Application for a Non-Material Amendment Following a Grant of Planning Permission

Erection of a one and a half storey extension and detached outbuilding

DC/22/01866

End677/02A (Proposed works to dwelling)

TITLE  
**PROPOSED WORKS TO DWELLING PLANS & ELEVATIONS**

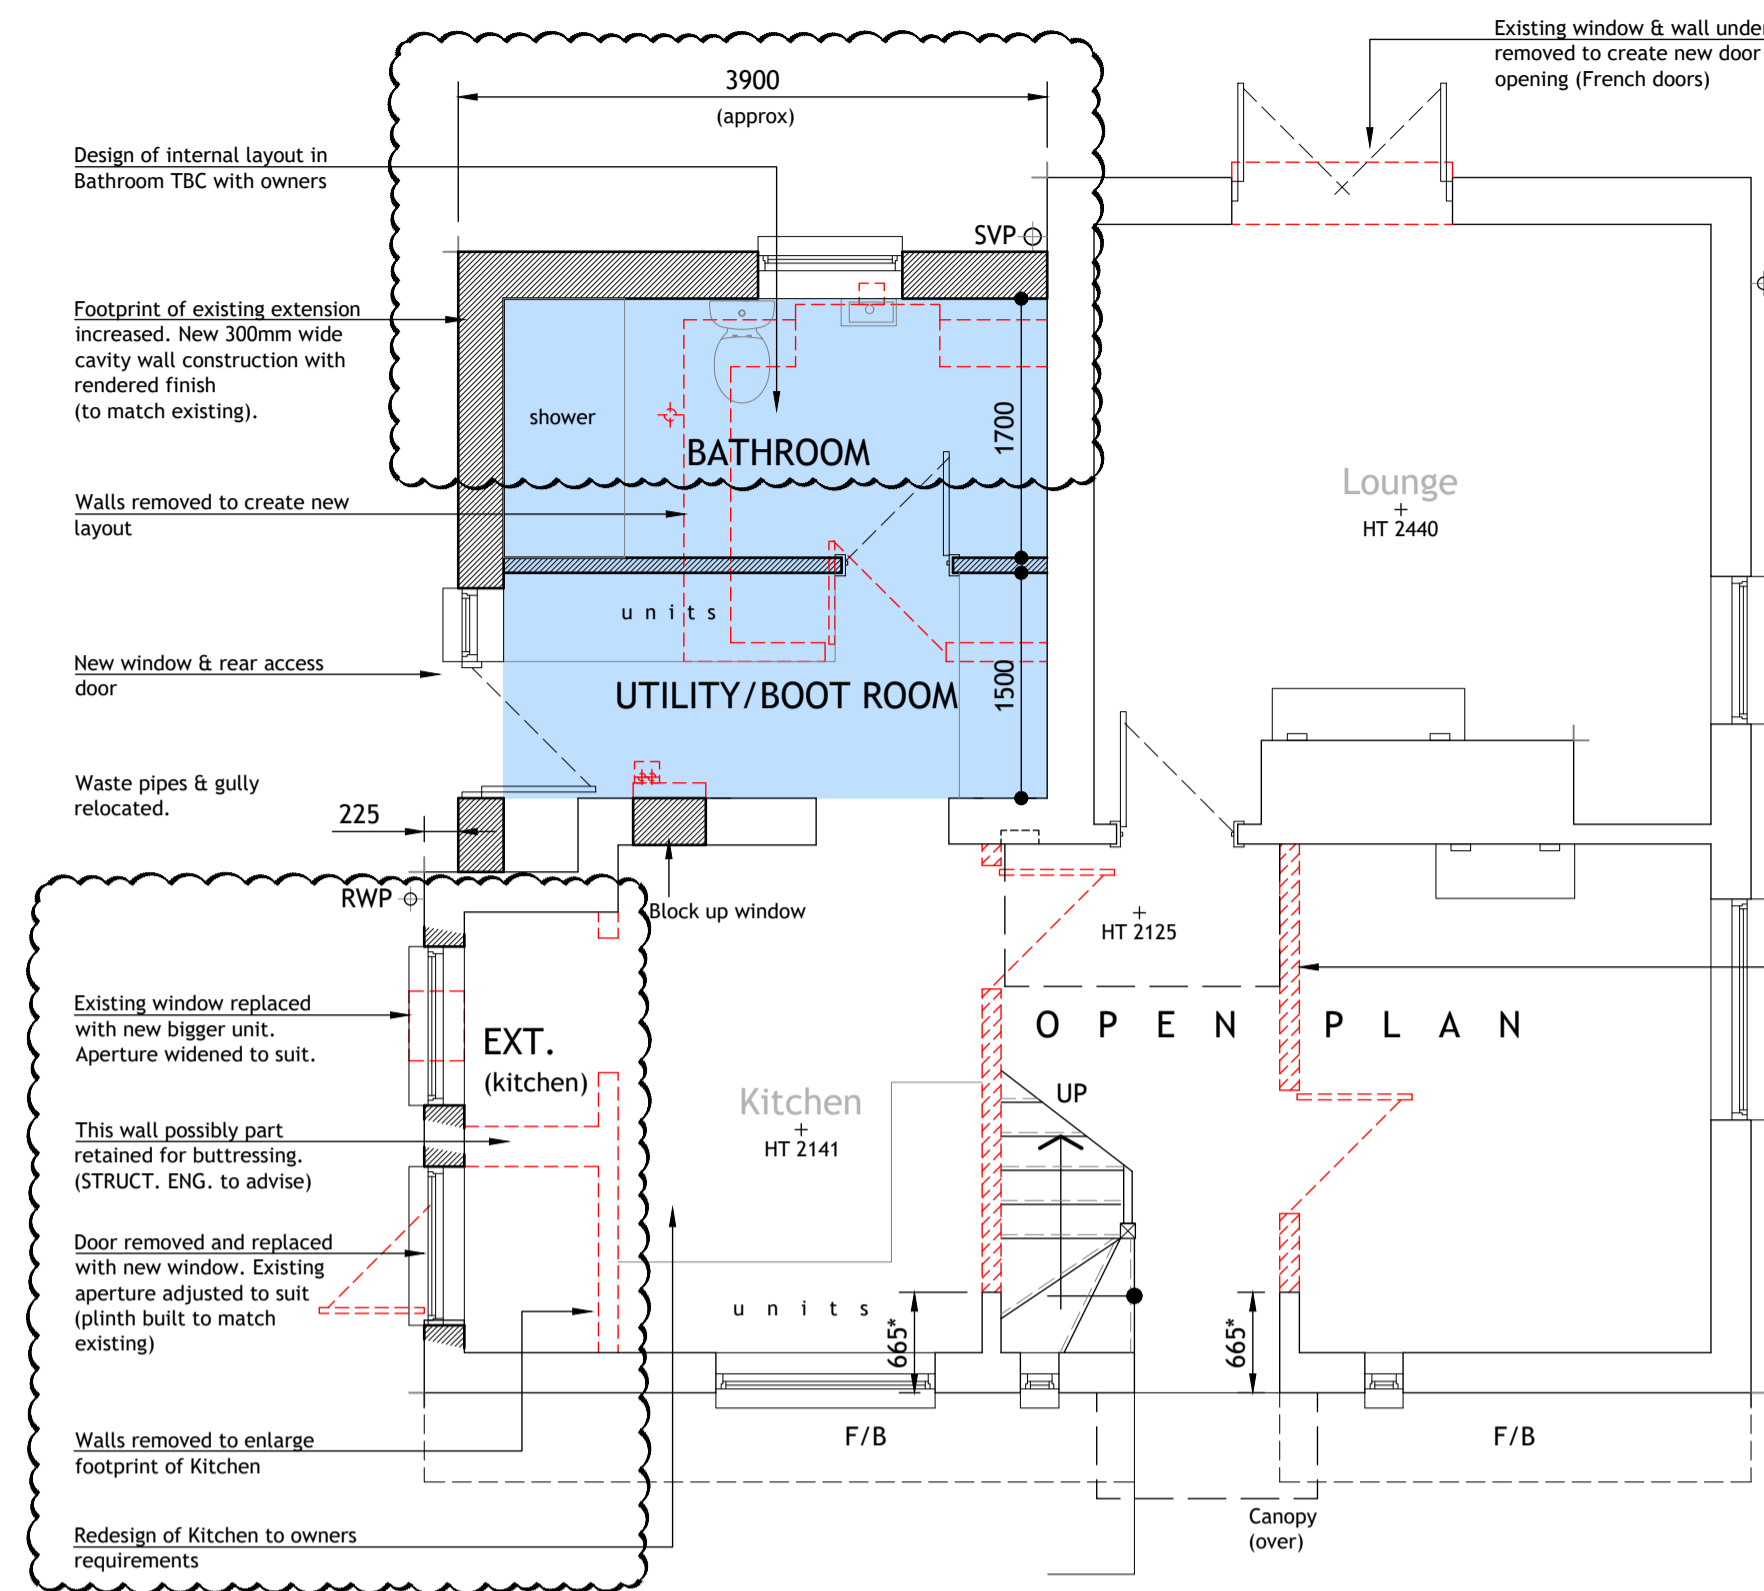
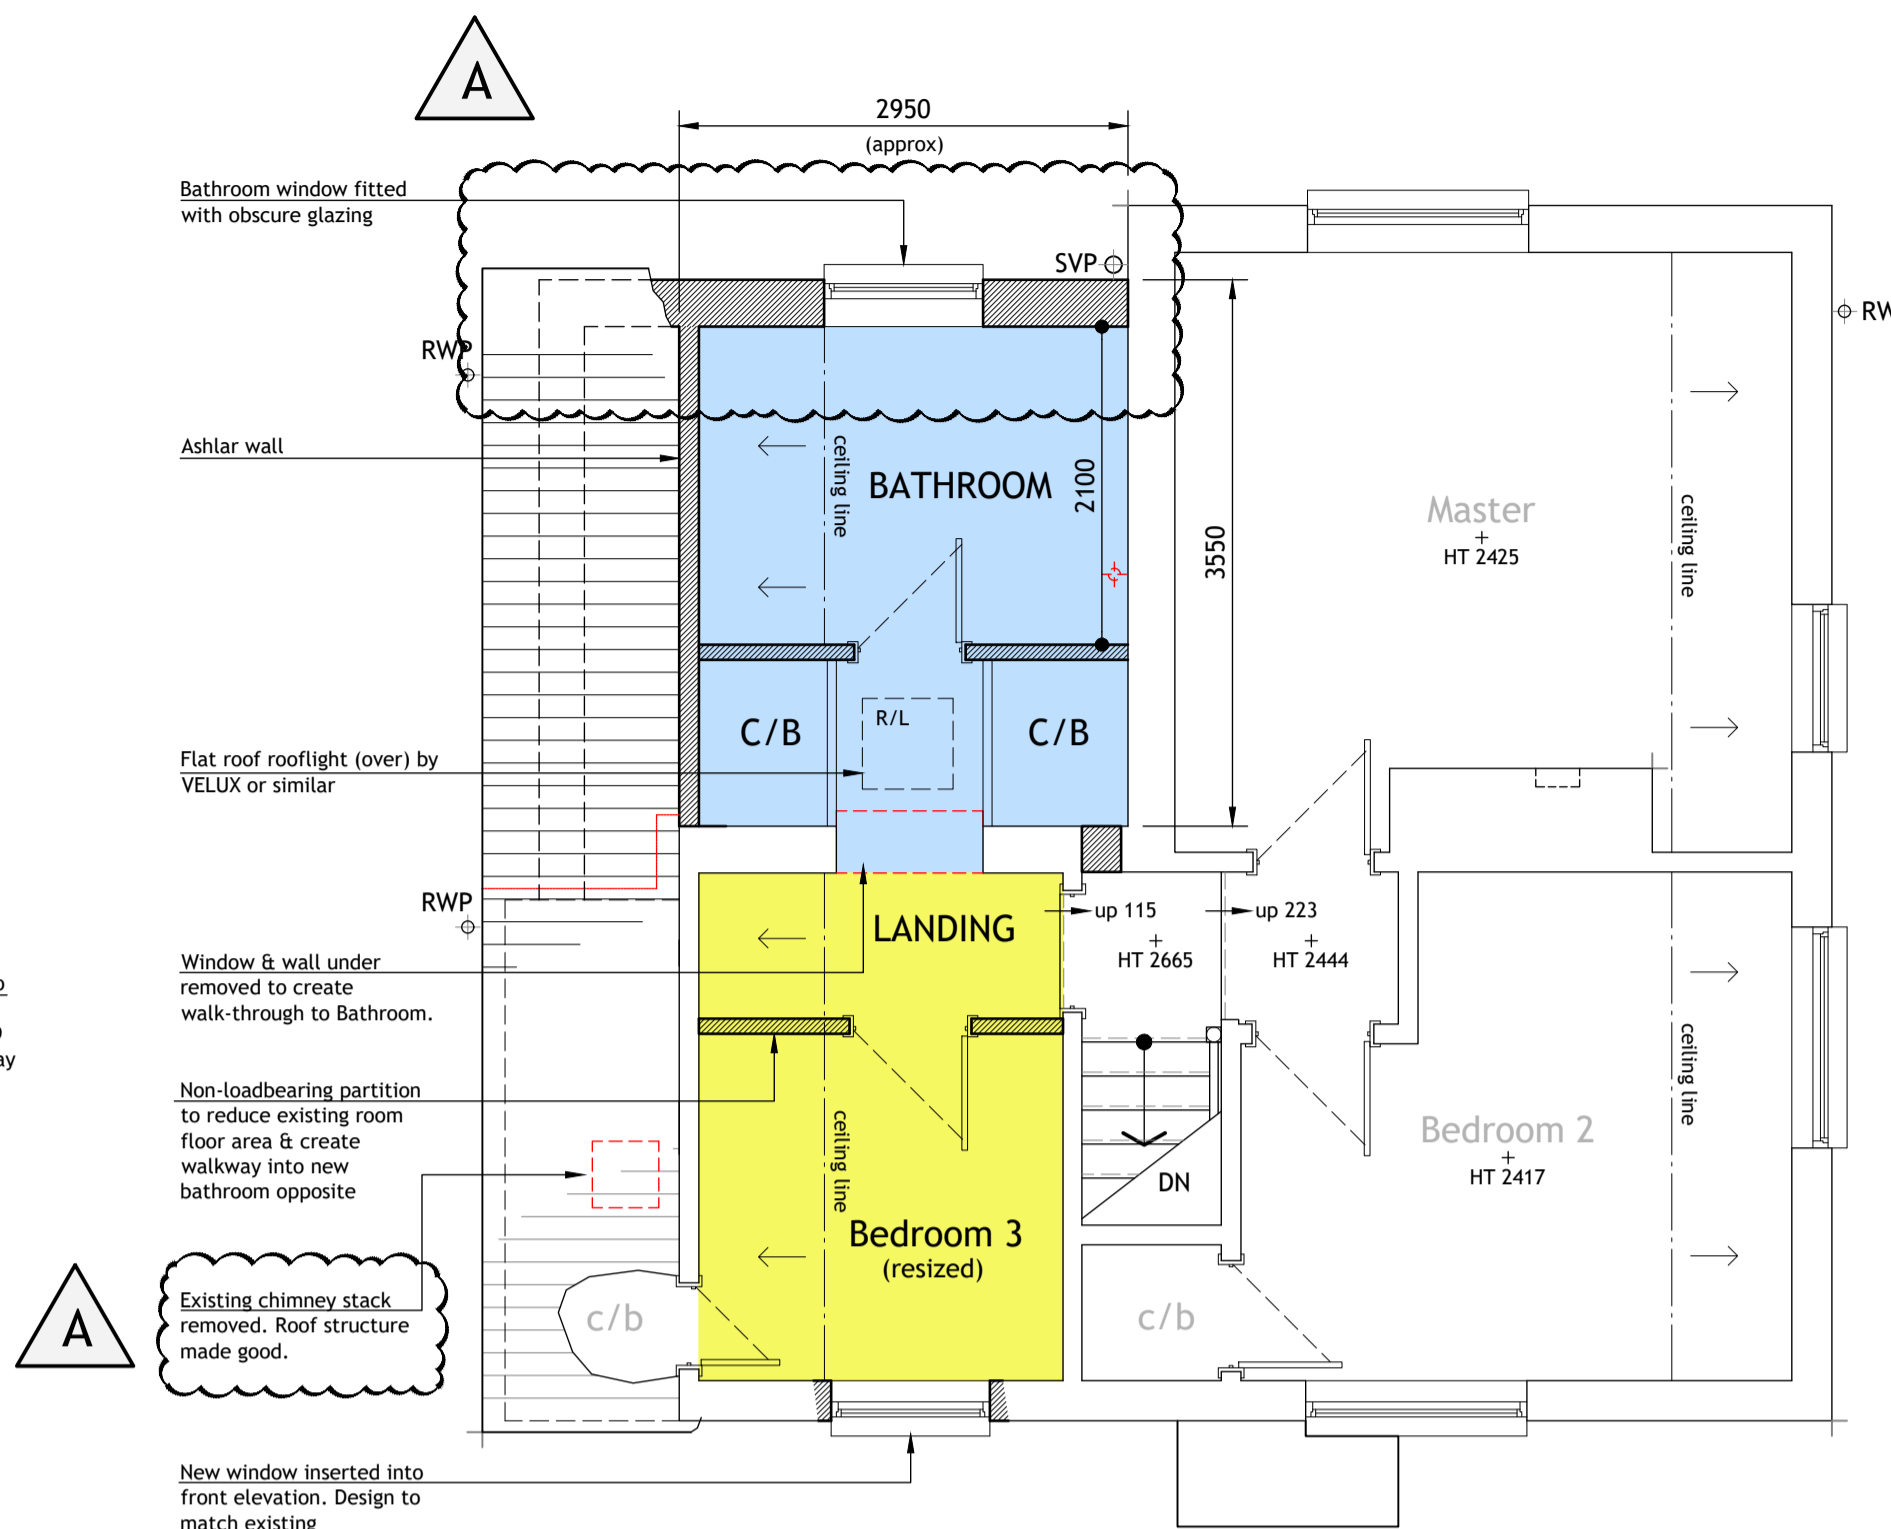
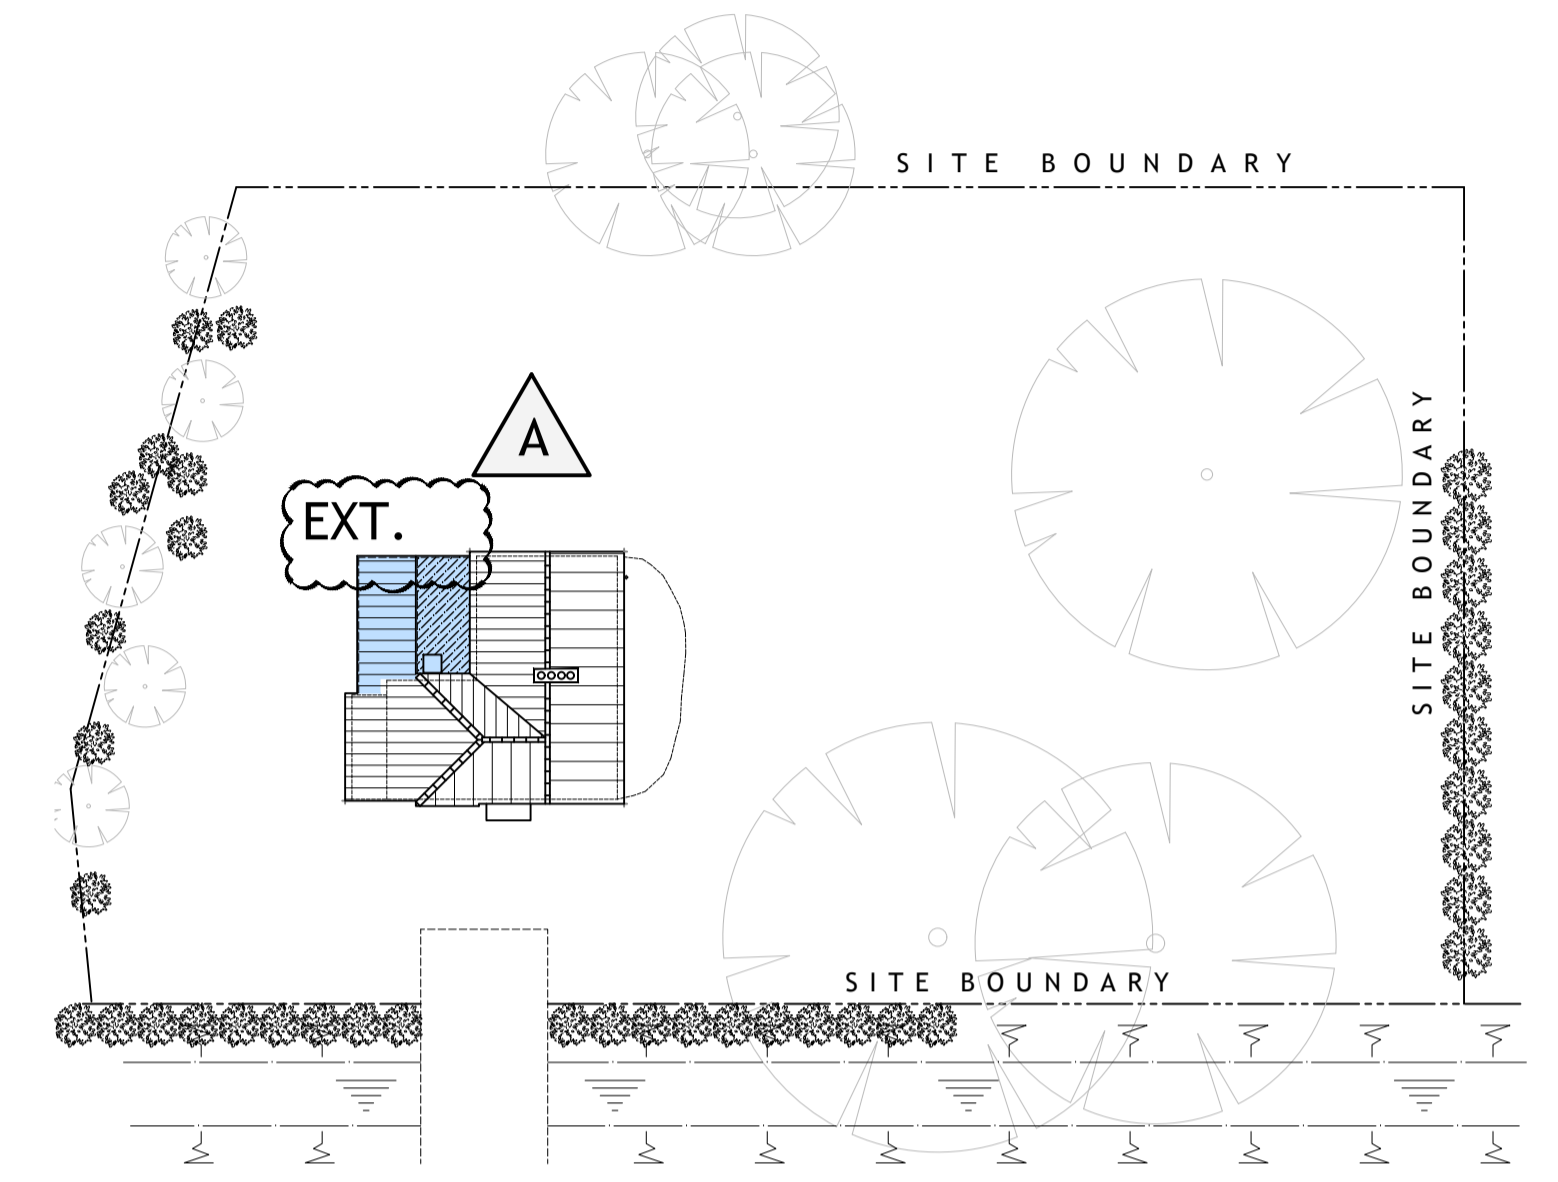
1. The rear extension is to be increased in depth by a further 450mm, albeit it is still articulated from the rear elevation of the cottage.
2. The existing door and window on the existing lean-to (south elevation) is to be replaced with 2x matching windows.
3. The existing narrow chimney stack emanating from the lean-to is to be removed.
4. The other changes are internal.
